Date: 18 July 2023
Our ref: 437197
Your ref: EN020002

NSIP Reference Name / Code: National Grid: Bramford to Twinstead Reinforcement / EN020002

Title: Natural England's relevant representations in respect of National Grid's Bramford to Twinstead Reinforcement

Figure 2.1 - Hintlesham Great Wood

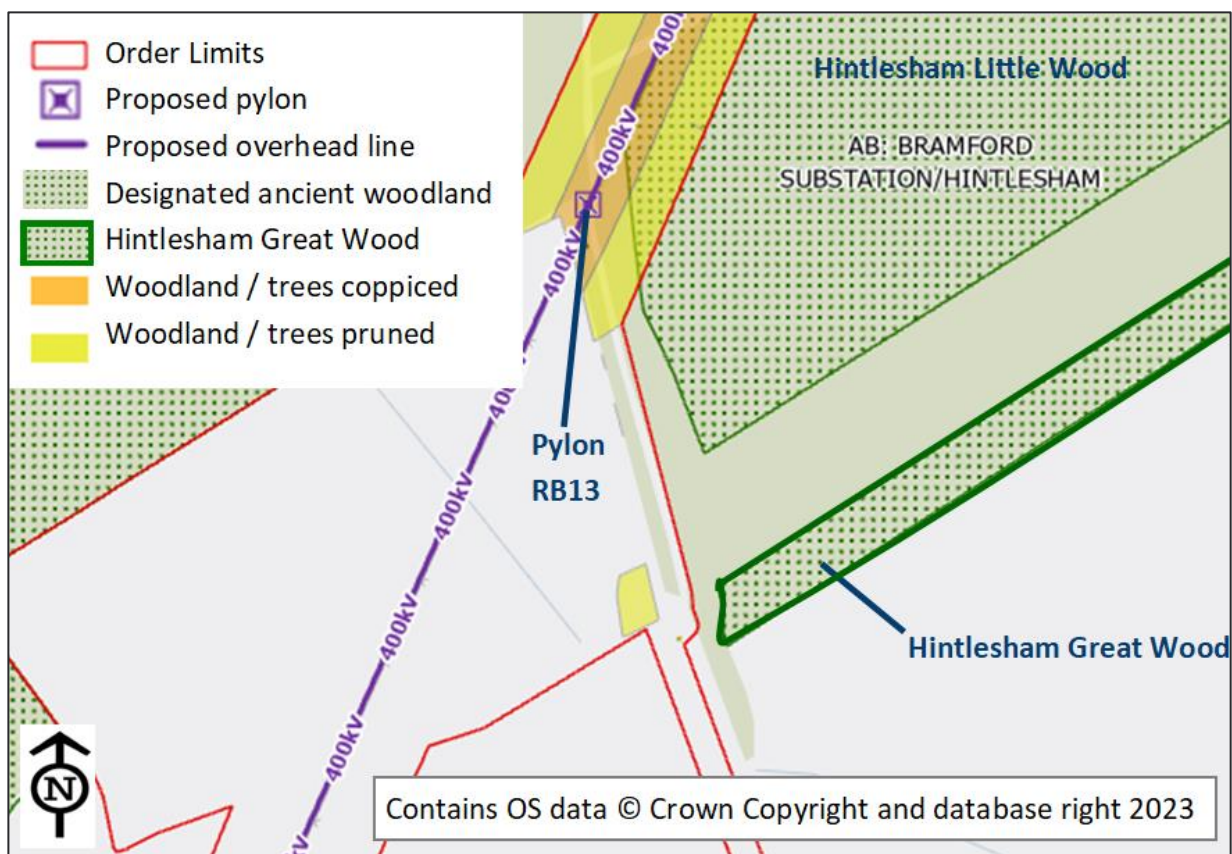
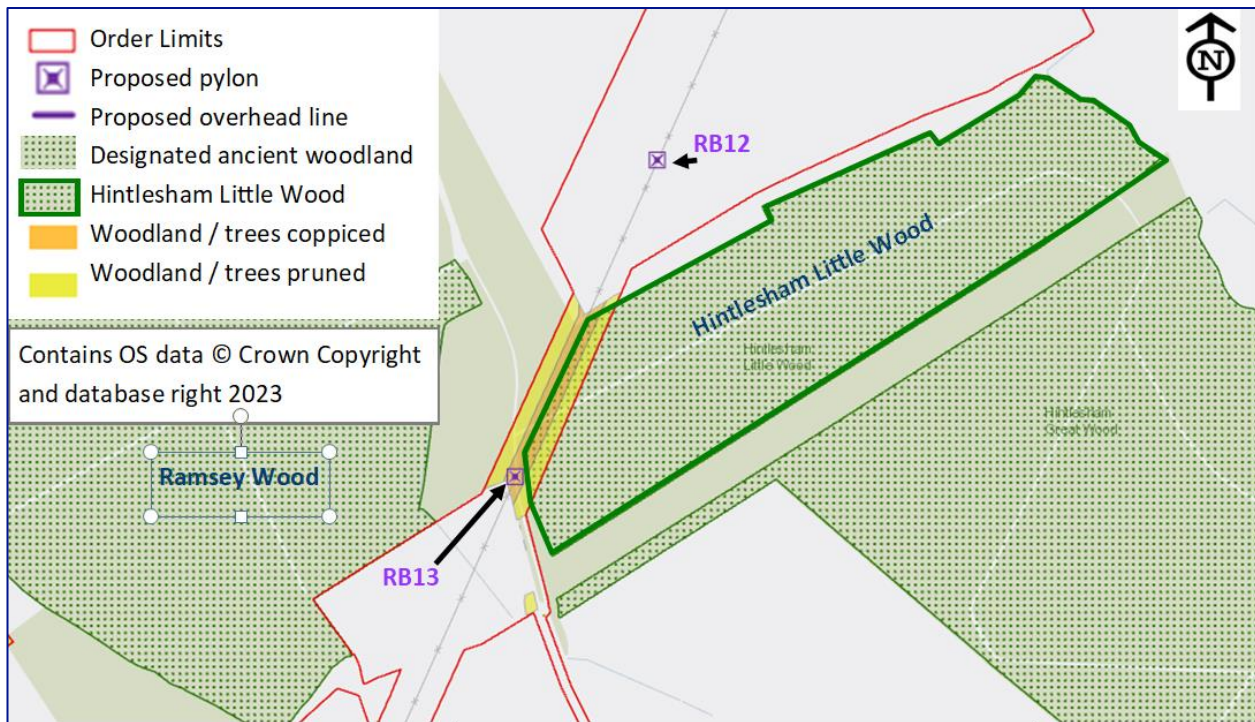
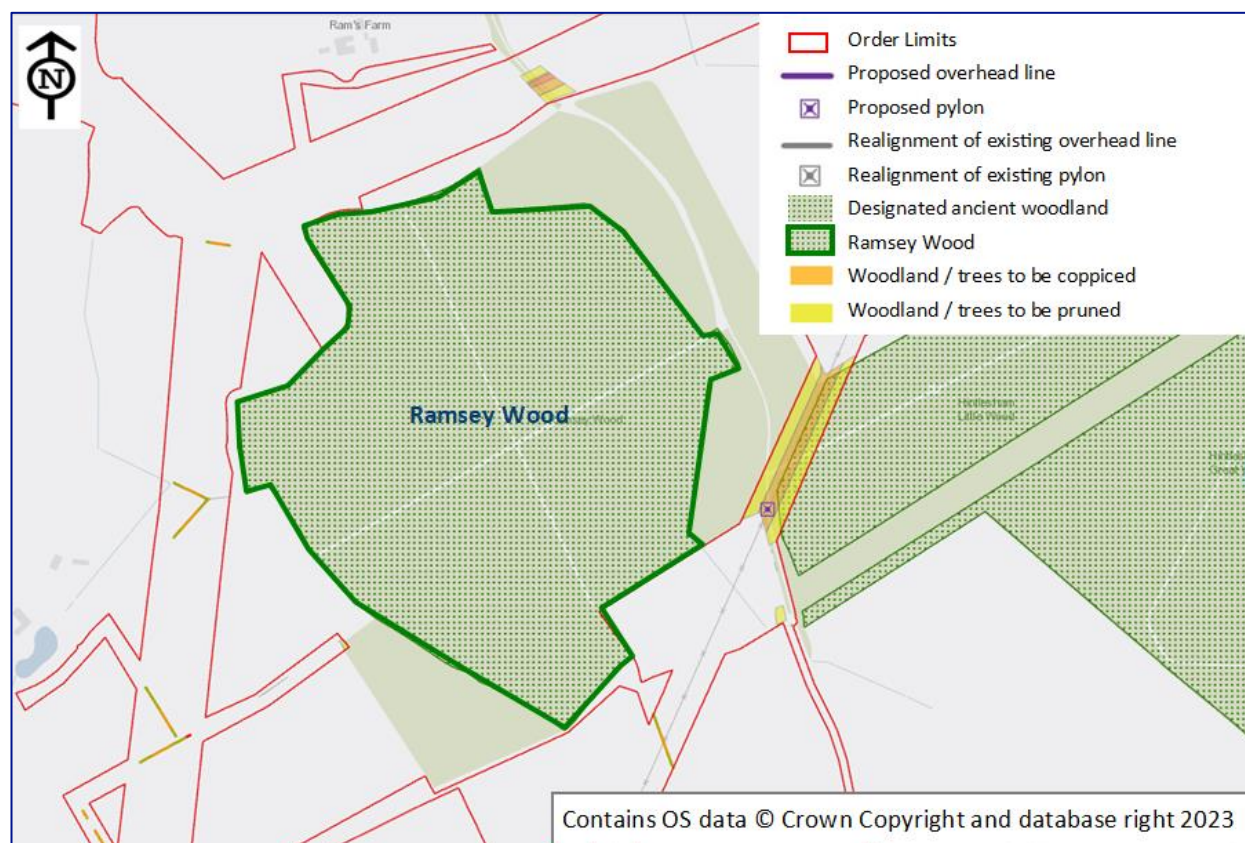
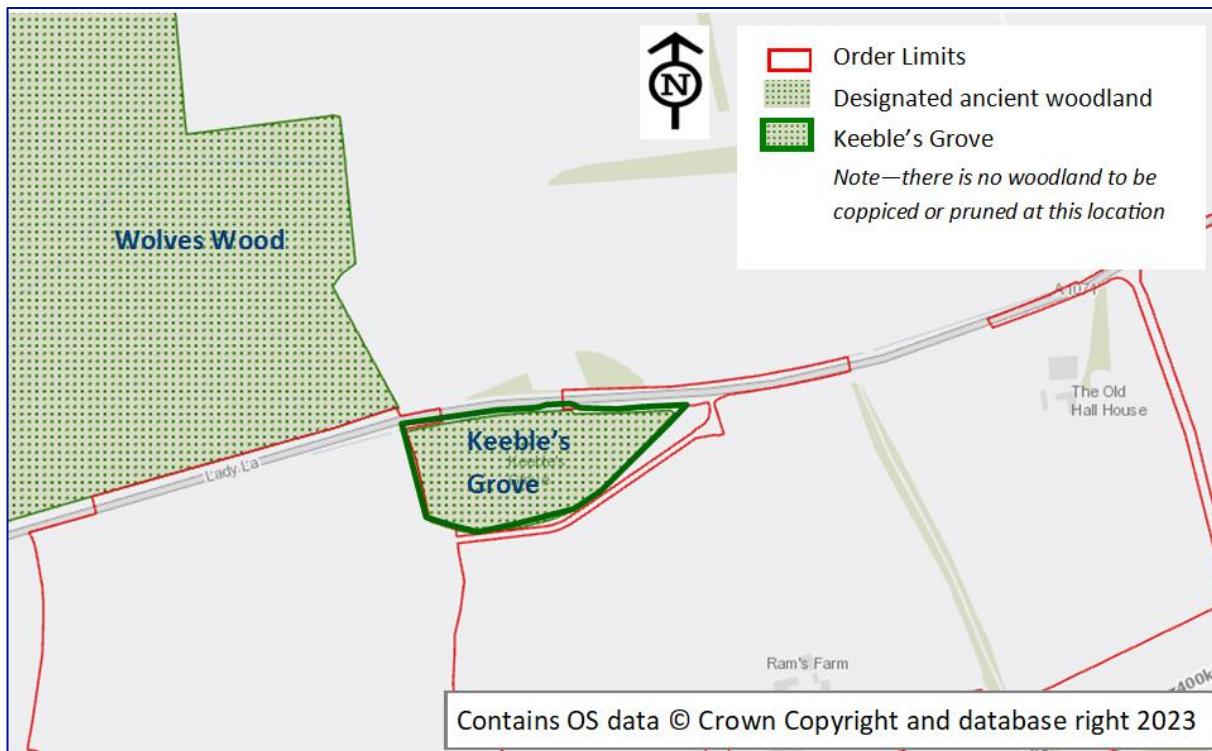
2.7.2.1 It is not clear that the works to be undertaken below the existing overhead line through Hintlesham Woods SSSI will be coppicing, rather than vegetation clearance. Verbal communication with the applicant has indicated that it is coppicing. However, Natural England seeks written confirmation that this is the case as it is not currently clear from the documentation provided. Natural England also requests that the impact from deer browsing is considered in the aftercare plan (section 9 of the LEMP).

2.7.2.2 Clarification is sought on why mitigation measures such as hand digging/ vacuum excavation are proposed within the 15m buffer around Hintlesham Little Wood (part of Hintlesham Woods SSSI) as this is not made clear in the documentation provided.

Figure 2.10 - Bushy Park Wood

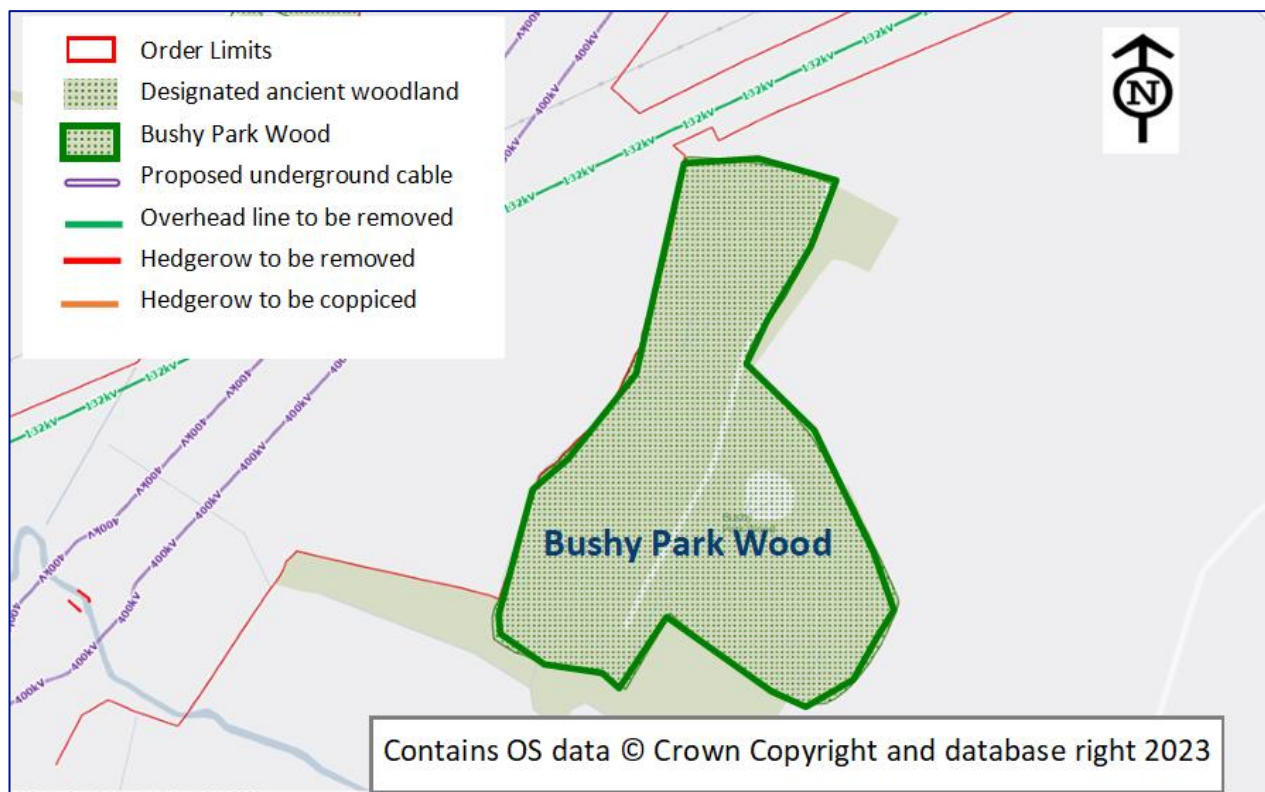
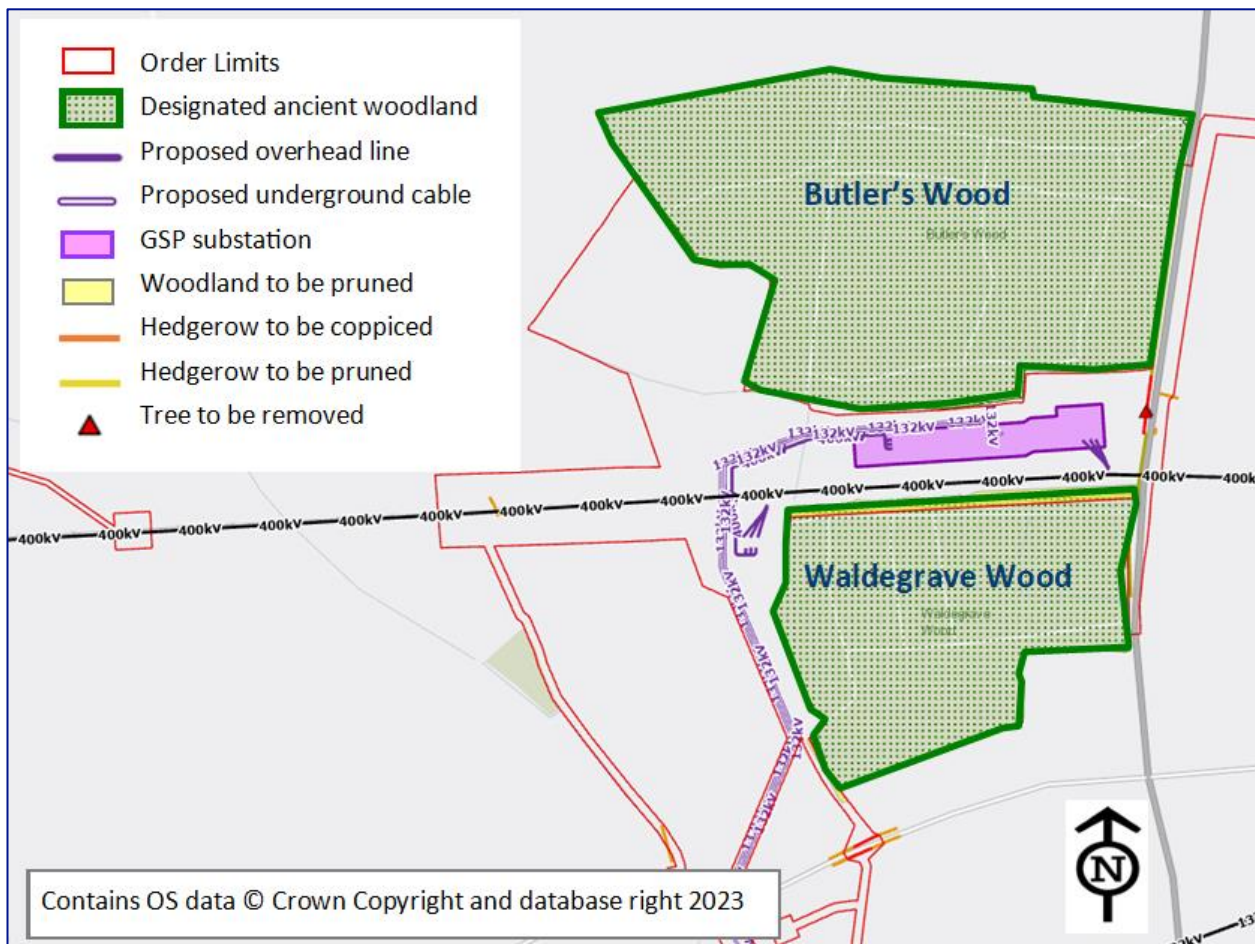
2.7.2.3 Application of Natural England's standing advice for ancient woodland, ancient trees and veteran trees should be applied and the implementation of the mitigation hierarchy reviewed for the following ancient woodland sites: Bushy Park Wood, Butler's Wood and Waldergrave Wood.
